Project Name: Unser & McMahon

April 13, 2021

**RE: UNSER/MCMAHON MIXED USE 10715 UNSER BLVD
EROSION AND SEDIMENT CONTROL PLAN
RESPONSE TO COMMENTS (A11E017)**

- Notes:
1. Ends of wattles shall be turned slightly up slope, against flow
 2. Ends shall extend minimum of 6 inches above top of wattle at centerline overflow

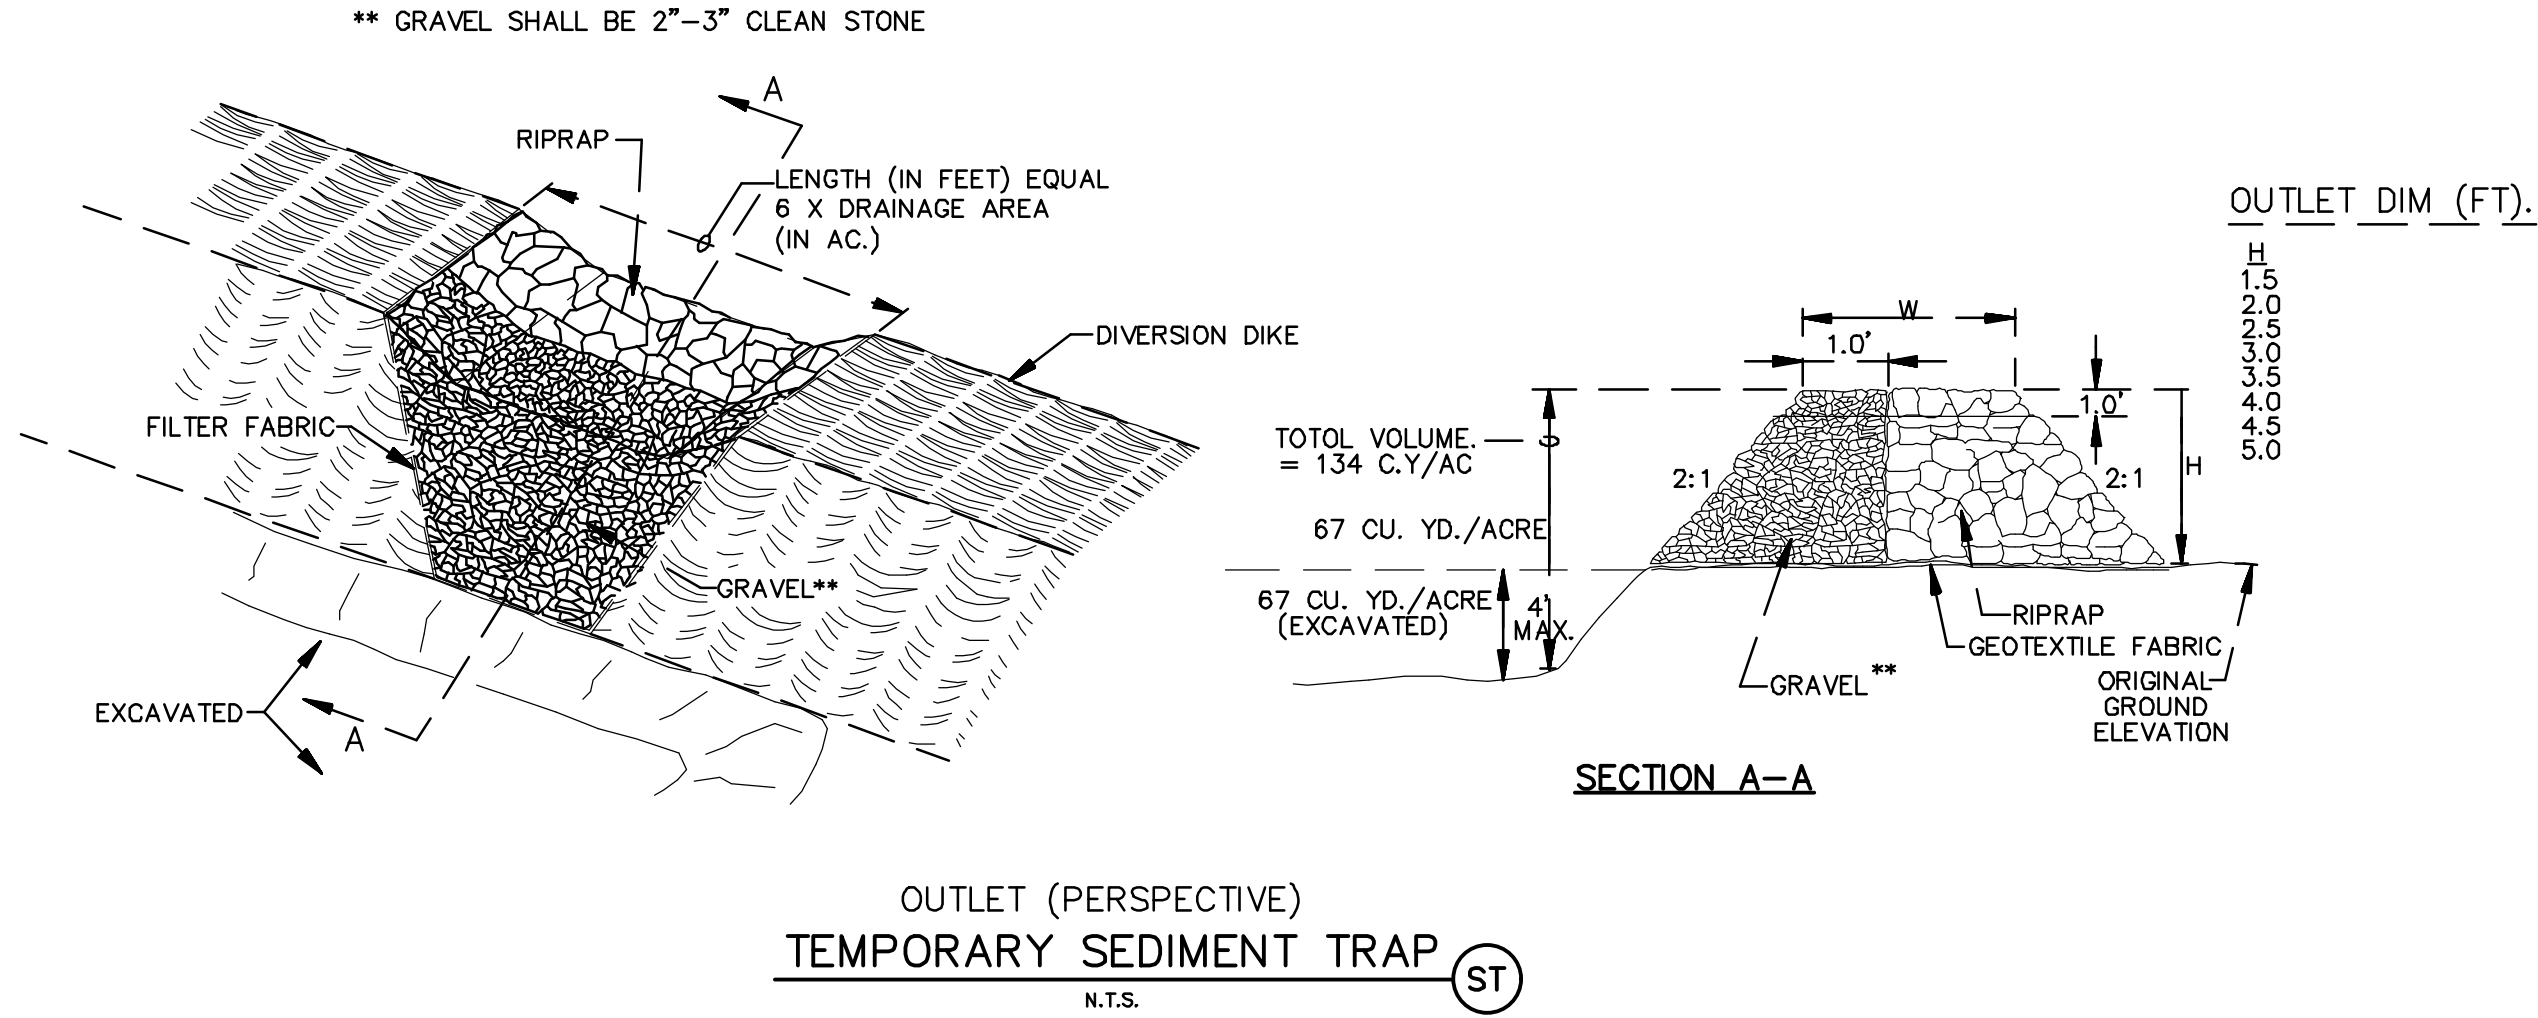
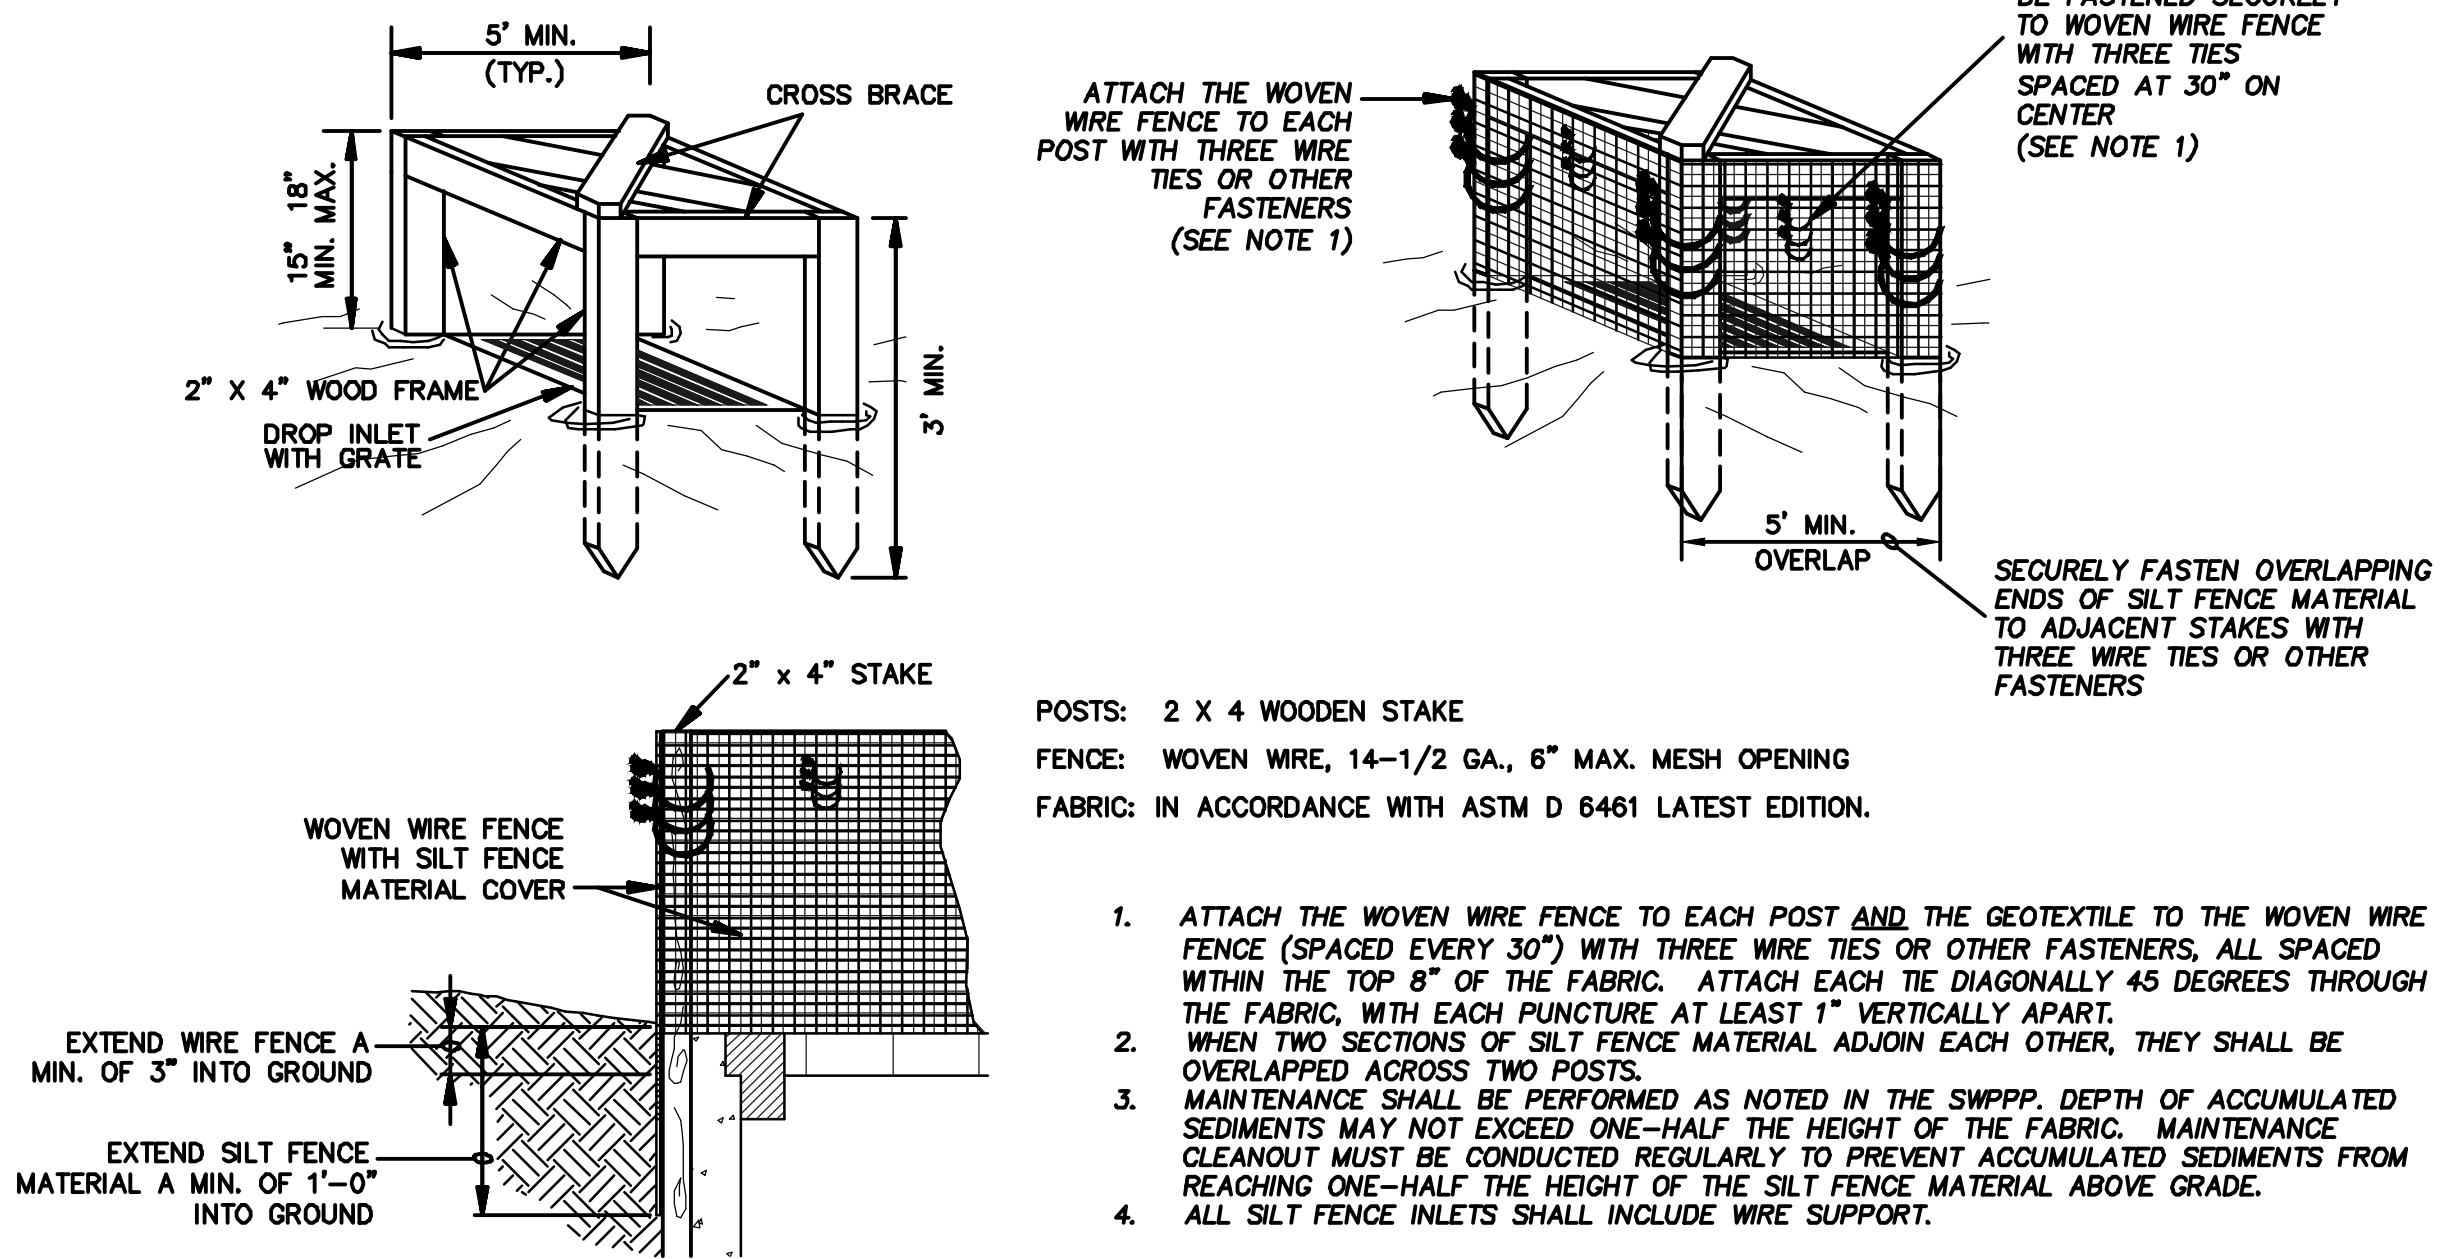
1. The north arrow is pointing west.
Response: The north arrow is now oriented in the correct direction.
2. The limits of disturbance must include all frontage improvements (CGP7.2.4.b.i).

3. The existing and proposed grades must be shown on the plan, and they must agree with the Grading Plan approved by Hydrology (CGP7.2.4.b.ii).
Response: The existing and proposed grades are now shown on the plan; the grades are the same as the approved Grading Plan stamped 08-04-20.

4. The locations of structures and other impervious surfaces. Differentiate between existing, construction this project, and future construction by others (CGP7.2.4.b.v).

5. Describe undisturbed and pre-construction ground cover (CGP7.2.4.e).
Response: The pre-construction ground cover description can now be found on the plan at the bottom of the Legend table. The ground cover described is undisturbed and uncompacted soil with native vegetation.

6. List operators on the plan, including name, phone #, and email address. If unknown, leave blanks to be filled in later (CGP7.2.1).
Response: Operators are unknown at this time, so a "List of Operators" to be filled out at a later date is now shown near the lower right corner of the plan.

7. Identify stormwater team members responsible for sediment removal, BMP maintenance, and inspections on the plan, including name, phone #, and email address. If unknown, leave blanks to be filled in later (CGP7.2.2).

8. Describe the nature and extent of construction activities (CGP7.2.2), including a) nature of construction activities, b) size of the property, c) size of disturbed area, d) description of construction support activities, e) size of maximum disturbed area, and f) project schedule. The three phases of this project are Grading, Infrastructure, and Sales. Provide a brief description of the nature of each phase. Include in the schedule the initial establishment of the sediment trap before the grading phase, the removal of the sediment trap and placement of additional silt fence to keep sediment out of the onsite street after the infrastructure phase, and the annual maintenance plan of the BMP's and stabilization practices (temporary and permanent) during the sales phase. Describe the expected circumstances of Termination of permit coverage including a final stabilization specification or sale and transfer to other operators. The operators and team members for each phase should be identified in 6 and 7 above.

9. Stabilization measures (CGP7.2.6.b.vi), including a) specific vegetative and non-vegetative practices, b) deadlines, c) beginning and ending dates of the seasonably dry period, d) procedure to comply with The Weed Removal Ordinance (§ 9-8-1) during sales phase:

10. Soil Information – add a table with name type, particle sizes, and erodibility factor (CGP2.1.1)

12. Vicinity Map – add a zone atlas map clearly indicating location and street names.

13. City Standard ESC Notes attached.

Response: The plans have been updated to show the limits of disturbance to include all frontage improvements. This includes 1) the driveway entrances off of Unser, McMahon, and Bandelier, 2) the Bandelier roadway extension to McMahon, and 3) the sidewalk along the existing Bandelier Road. Sidewalks and trails already exist along Unser and McMahon frontage so the limits of disturbance come up to the back of those walks.

Response: The plan has been updated to show only what is to be constructed in this project. The scope of work in this project includes mass grading, storm drain installation, paving of access road internal to site, and the frontage improvements as mentioned in comment response #2.

Response: Stormwater team members are unknown at this time, so a "Stormwater Team Members" section to be filled out a later date is now shown near the lower right corner of the plan.

Response: A "Nature and Extent of Construction Activities" notes section has been added to the plan to include all of this information. This would include, nature of construction activities, property size, disturbed area size, description of construction support activities, max disturbed area, project schedule, grading phases, infrastructure phase, sales phase, annual inspections, NOT termination, stabilization measures, and City Weed Removal Ordinance. A BMP maintenance notes section is also shown on this plan sheet.

Response: The added "Nature and Extent of Construction Activities" notes section on this sheet includes the stabilization measures.

Response: A soil information table has been added to the lower right corner of the plan identifying this soil information.

Response: Vicinity/zone atlas map has been added to the upper right corner of the plan.

Response: The city standard ESC notes have been added to the lower left corner of the plan.
